From: Clerk [REDACTED]
Sent: 03 March 2021 13:46
To: Planning.Responses <Planning.Responses@arun.gov.uk>
Subject: RE: Planning Consultation on: BN/16/21/HH

Application No: BN/16/21/HH
Registered: 11th February 2021
Site Address: 8 Collins Close Chichester PO20 3JT
Grid Reference: 494588 105664
Description of Works: Single storey detached garage to the front of the property

Mr. & Mrs. Turner
8 Collins Close, Eastergate, Chichester
West Sussex PO20 3JT
NEW GARAGE PROPOSED SITE
Date: FEB 2021 Scale 1:200 Dw no. PR.S. 01

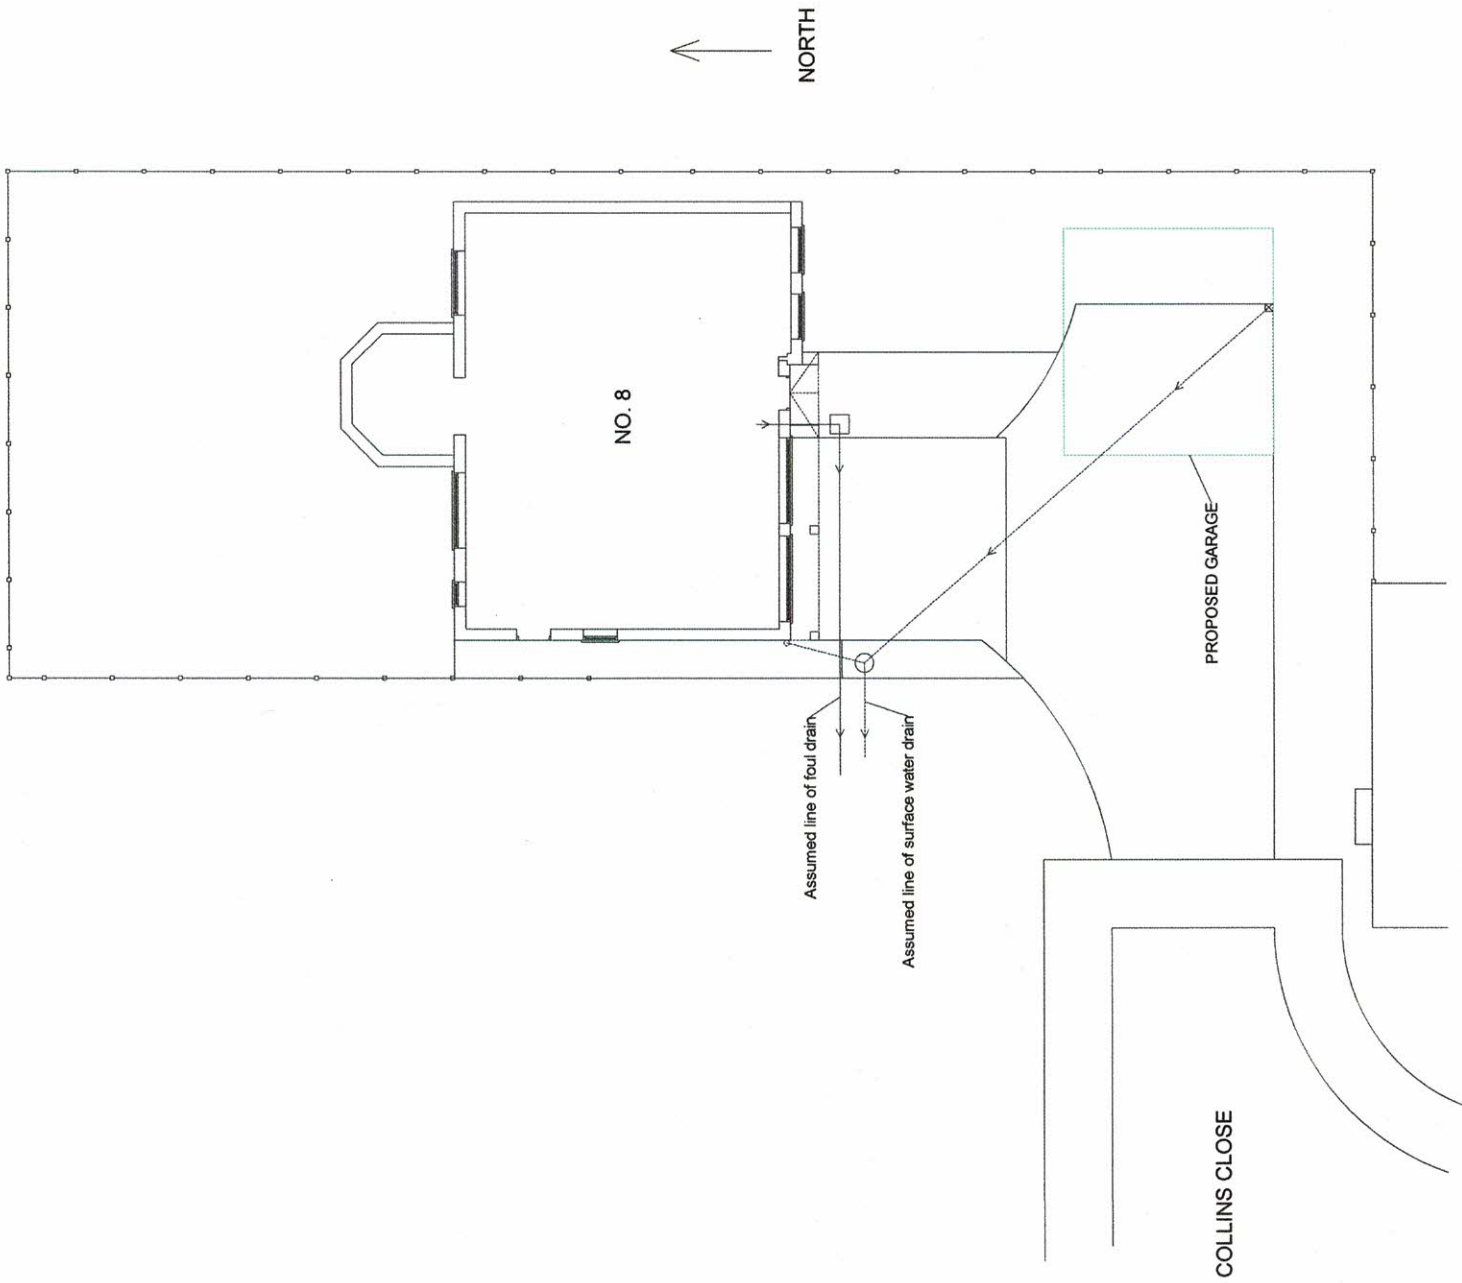
At a meeting of the Barnham and Eastergate Parish Council's Planning & Environment Committee held on 2nd March 2021 the Committee resolved to submit an objection to the above application as the proposed garage would be built in front of the building line and if the Council were minded to approve the application they would ask that serious consideration be given to asking the applicant to build a car port rather than a garage as the visual impact would be less intrusive.
